Re: Variation of condition two associated with application 2023/62/91345/E for the erection of a single storey building with roof top plant area to provide outpatient theatres, treatment rooms and consultant rooms with link to Boothroyd building, including demolition and remodelling of existing ramp and associated landscaping and drainage.

Berrys have been assisting Darwin Group to address several amendments that are now required for the new NHS facility at Dewsbury District Hospital, Halifax Road, Dewsbury, WF13 4HS. These proposed amendments are due to further detailed design stages and updated safety requirements.

This s73 application is therefore seeking to vary Condition 2 of the planning permission ref: 2023/62/91345/E.

Proposed_North_Facing_Elevation
1 : 200

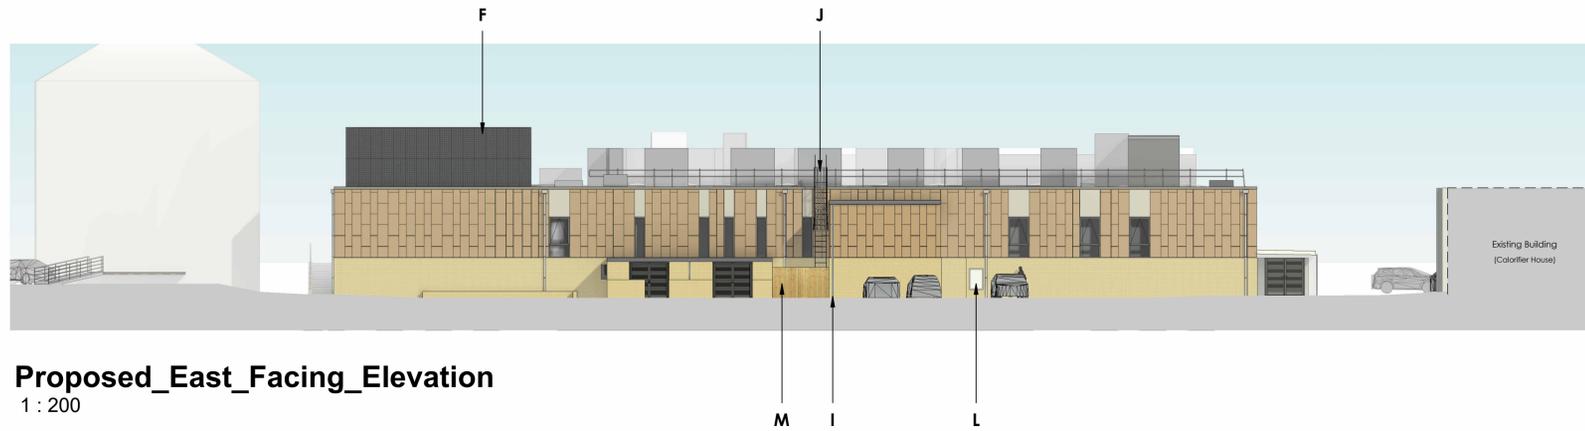
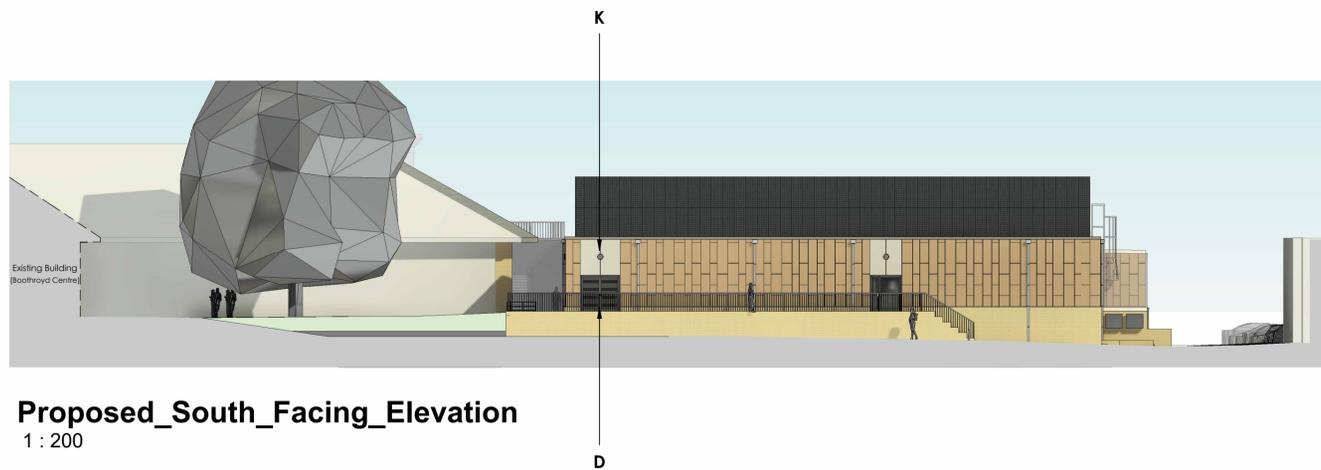
Addition of Low Voltage Rooms on the Northern Elevation

It was identified during a further detailed design development that the existing hospital's electrical infrastructure could not adequately support the new building's power demands. As a result, additional electrical infrastructure is now required. This is in the form of two Low Voltage (LV) rooms. Without the LV rooms, the building will not be able to function adequately. As the proposed use will include theatres and treatment rooms, the additional electrical infrastructure is deemed essential as it will be providing power to support critical health procedures.

The proposed LV rooms are proposed to be located on the northern elevation as this elevation is hidden from public areas but also accessible and available to hospital estate maintenance staff. In addition, a protective crash rail has been installed to provide protection and to improve safety. A self-supporting wall has also been proposed adjacent to the door entrance to prevent the door swinging onto the walkway as well as acting as a sacrificial barrier.

DRAWING TITLE: Proposed Building Sections

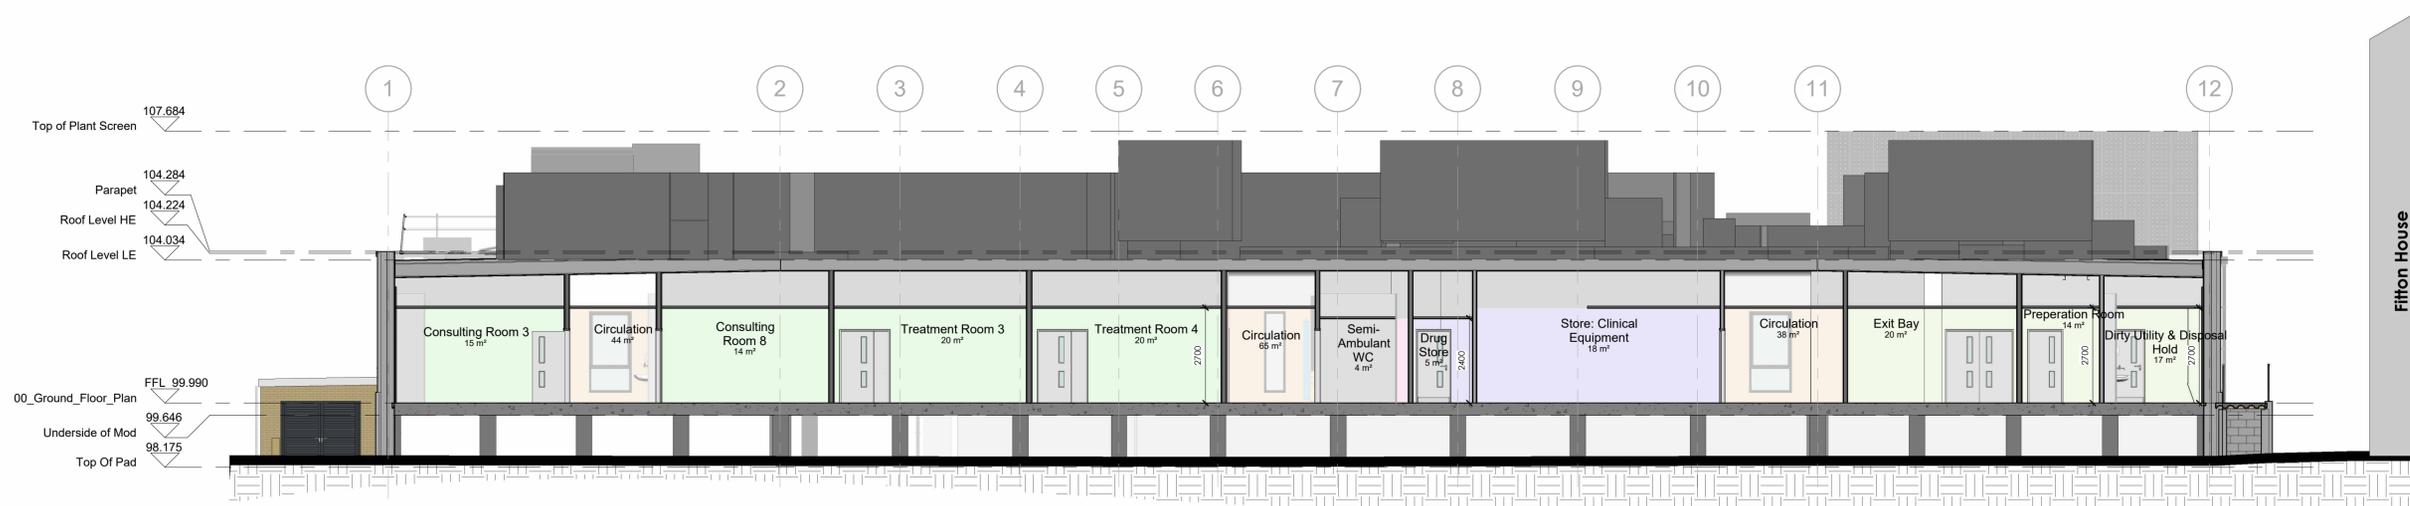
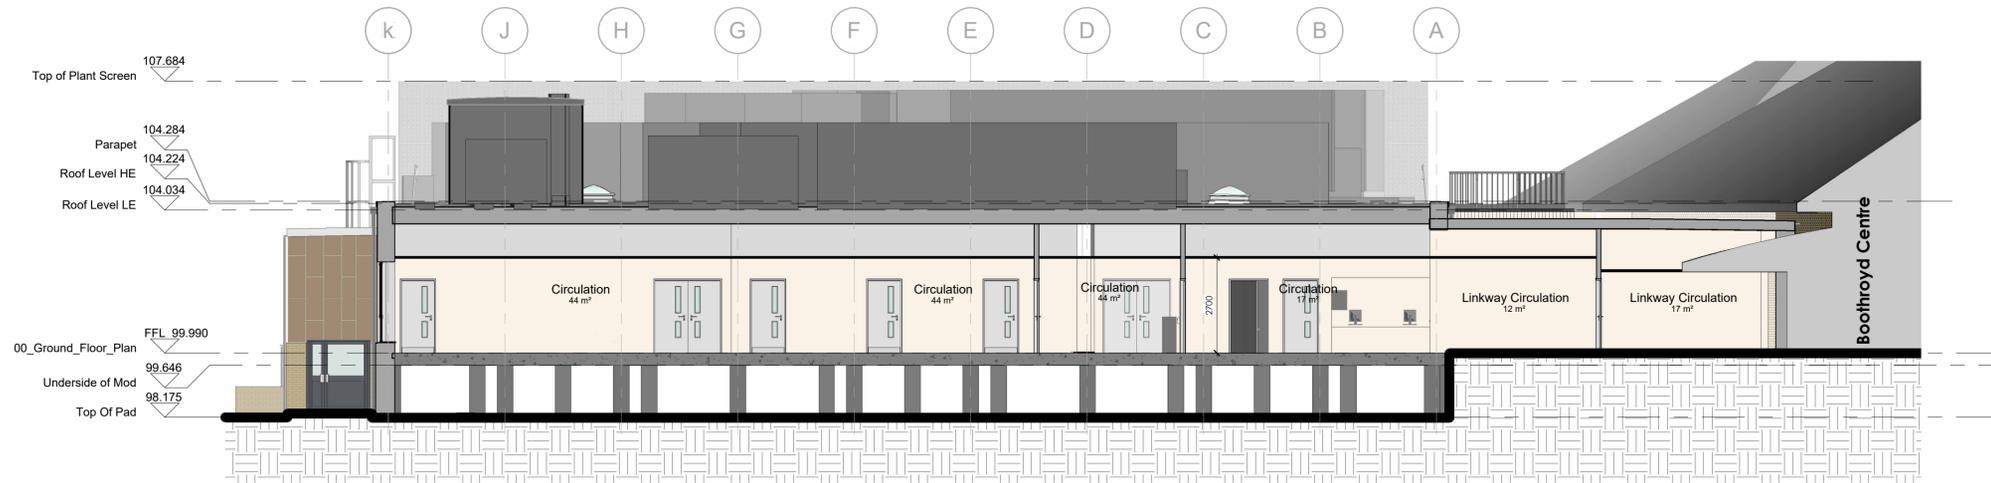
Addition of emergency hatch to the undercroft

Following the specialist recommendation to install a gas membrane, the undercroft area of the building now constitutes a substantial enclosed volume requiring adequate cross ventilation to ensure safe environmental conditions. A compliant ventilation strategy was implemented to meet building and health and safety regulations.

As electrical services run through the undercroft, an emergency access hatch was installed as a precaution. While routine access is not required, the hatch provides a vital safeguard, enabling emergency entry if necessary. The hatch, therefore, improves safety, accessibility and improves the function of the building.

00_Ground_Floor_Plan 1:100

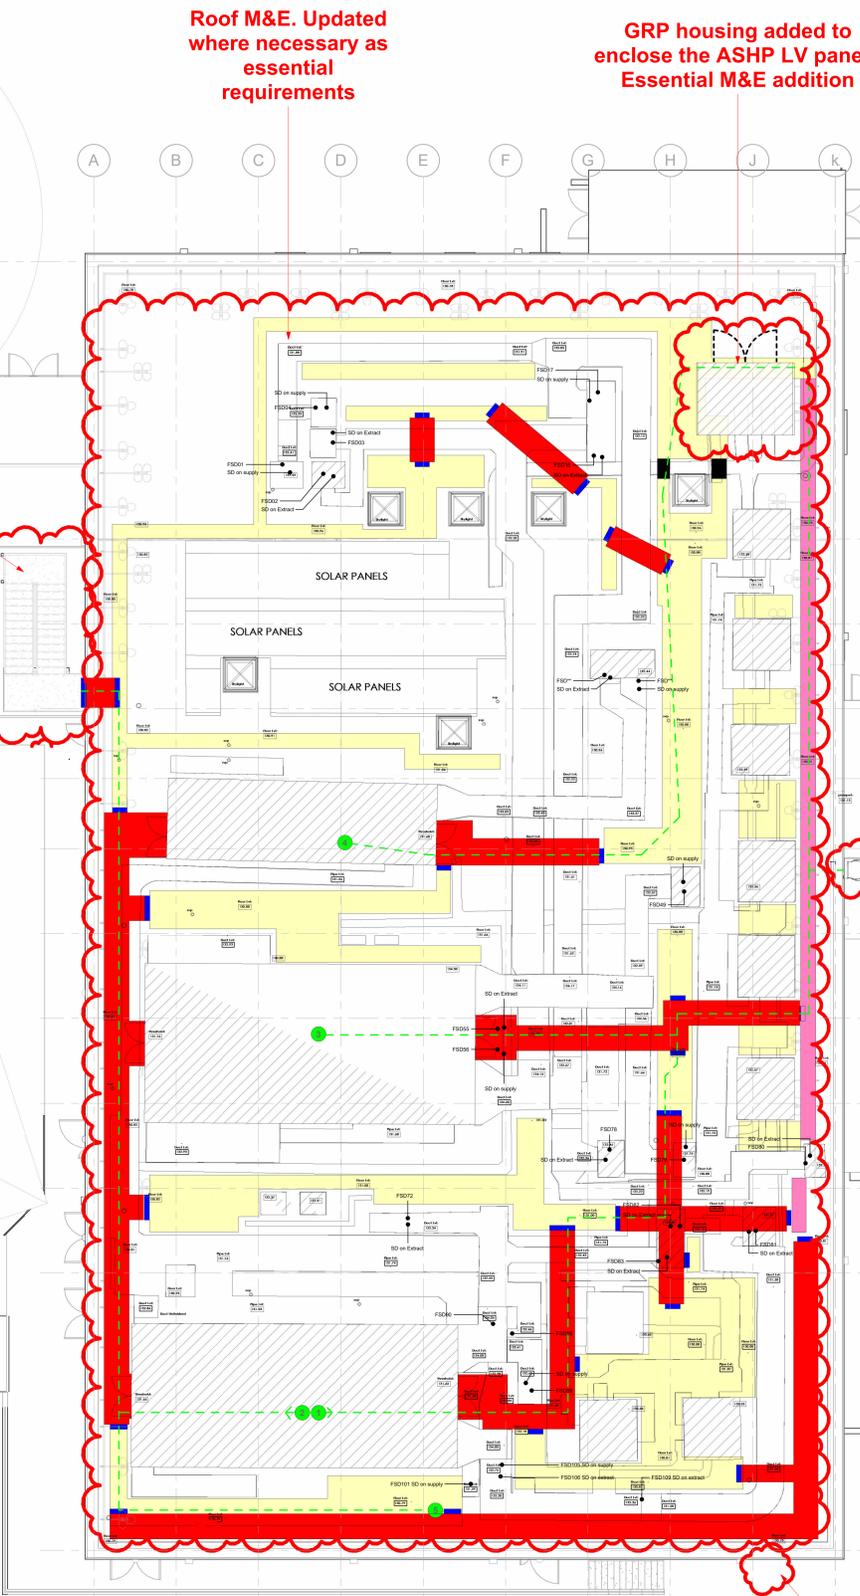
CAT Ladder relocation on the Eastern Elevation

The CAT ladder on the south elevation has been relocated to improve the functionality, safety and visual appearance of the building. The main reason behind the relocation is due to the fire strategy and safety requirements. The escape distances for a secondary means of escape must comply with building regulations. Therefore, the applicant has had to relocate the ladder following the approval of an unsuitable original design.

In addition, the CAT ladder was originally located on a pedestrian route in a visibly prominent location. The proposed new location will have greater safety and visual

benefits as it is located within an enclosed and secure area. This will reduce unauthorised access which, in turn, further improves the site safety.

New enclosed staircase on the Western Elevation

The existing CAT ladder on the western elevation is proposed to be replaced with an external staircase after a design review determined it to be a safer and a more practical solution for roof access. Unlike the CAT ladder, the staircase allows easier and safer movement of maintenance staff and equipment, in line with CDM Regulations 2015.

To complement the building's appearance, the staircase was clad on three sides with RAL7016 metal panels, providing weather protection and visual consistency. The cladding stops at parapet height to minimise visual impact, avoiding the need for a bulky enclosed structure. Access is secured with a lockable gate, limiting use to authorised maintenance personnel.

Addition of Fence on the Eastern Elevation

The proposed relocation of the CAT ladder between the IPS/UPS rooms and the lift was reconsidered due to significant safety and security risks, including the potential for unauthorised roof access. In accordance with fire safety protocols, the CAT ladder is now designated solely as a secondary emergency escape route, not for routine access.

Primary roof access is now provided by the external staircase, offering a safer and more controlled entry point for maintenance. To secure the CAT ladder, a vertical close-boarded timber fence with a lockable gate was installed around the area, limiting access to authorised personnel. This enclosed space also houses condenser pumps, providing a secure and compliant location for essential air conditioning equipment. As the building will be used by the public, having enclosed and controlled access is a key safety feature for the building.

Addition of an IPS/UPS room on the Eastern Elevation

Like the LV panel installation, the IPS and UPS rooms are essential to the building's electrical infrastructure. To meet technical requirements and to optimise internal space, these rooms are best housed in an external outbuilding with direct external access. This setup improves ventilation and environmental control, ensuring reliable performance of sensitive and powerful equipment. As previously mentioned, the proposed use will include theatres and treatment rooms therefore, the additional IPS/UPS rooms are deemed essential and are critical in the running of the building.

Positioning the rooms outside also reduces fire load and operational risk within the main building. Additionally, a self-supporting wall was constructed next to the outbuilding to allow safe door operation without obstructing pedestrian routes. This wall also acts as a sacrificial barrier, offering protection against potential collisions and safeguarding the infrastructure.

Addition of mini plinth wall (Eastern Elevation)

The south-east corner of the building, located at the site's lowest point and densely packed with essential infrastructure, presented spatial and level-related challenges. During landscaping works, sections of critical structural foundations were exposed. As altering these was not an option, a low plinth wall was introduced to conceal and protect them. This solution maintained the building's structural integrity while supporting the intended landscape design and pedestrian pathway. It also enabled the creation of a DDA-compliant accessible route, effectively balancing structural protection, visual coherence, and accessibility requirements. The building will be used by patients who may have mobility issues or require walking aids therefore, having a DDA compliant access with no exposed sections is a beneficial amendment to the building.

External Door removed from Western Elevation

The original design featured two separate plant rooms—one requiring dual escape routes and the other needing only single access. However, as the mechanical and electrical layout was refined, it became clear that a single, larger plant room would be more efficient. The internal partition is therefore proposed to be removed, merging the two rooms into one.

This combined space initially included three external doors, exceeding escape and access requirements. With services now aligned along the perimeter wall, the southernmost door on the west elevation was no longer needed. Its removal will improve the building's appearance without compromising safety, functionality, or compliance with Approved Document B of the Building Regulations.

Removal of wall and railing on Western Elevation

As construction progressed, the walkway and retaining wall design was revised to address technical and structural challenges. The original plan, featuring a retained walkway with deep foundations near the Boothroyd building, raised concerns about impacting existing foundations. Additionally, the inclusion of a gas membrane to mitigate ground gas risks made the initial design, which involved banking earth under the building, unsuitable due to restricted undercroft ventilation.

The revised solution introduced a single deep foundation along the west elevation, supporting a reinforced retaining wall to stabilise the ground while maintaining adequate airflow in line with CIRIA C665 guidance. It is important that there is adequate airflow in line with the guidance therefore, this proposed amendment will improve the safety of the building. This eliminated the need for a separate perimeter wall and handrail at the level change, allowing for a simplified, traditional pathway with pin kerbs and regraded landscaping—a more practical, buildable, and visually sensitive outcome. This also will improve patient access into the building.

Additional Roof Plant

During the transition from RIBA Stage 3 to Stage 4, the original M&E design was found to be inadequate, as the detailed performance requirements revealed a greater need for rooftop plant than initially anticipated. Additional roof plant is required to help provide essential services to the hospital building. Without the proposed plant, the building would have a reduced function which will in turn, limit the value and service of the healthcare facility. To meet the buildings demands, the proposed changes were made to the rooftop M&E layout. These are considered to be essential to the building's operation.

To reduce visual impact, plant was carefully positioned, screened, and kept to the smallest practical footprint. These adjustments were key to achieving the building's BREEAM Excellent rating, which required enhanced sustainability and energy systems—many dependent on rooftop installations. With no viable alternatives for location or massing, the final design reflects a carefully considered balance between technical necessity and the visual impact.

Addition of GRP housing

The GRP housing, like the LV and IPS/UPS rooms, protects a vital part of the building's power infrastructure—specifically the LV panel serving the rooftop Air Source Heat Pumps (ASHPs). To ensure efficient operation and compliance with BS EN 61439, the panel is located close to the ASHP units.

The GRP enclosure meets all regulatory size requirements while minimising visual impact. It is finished in a grey tone to match the existing rooftop plant, allowing it to blend discreetly into its surroundings. This carefully considered design ensures that the enclosure remains visually unobtrusive and in keeping with the building's overall aesthetic and context.
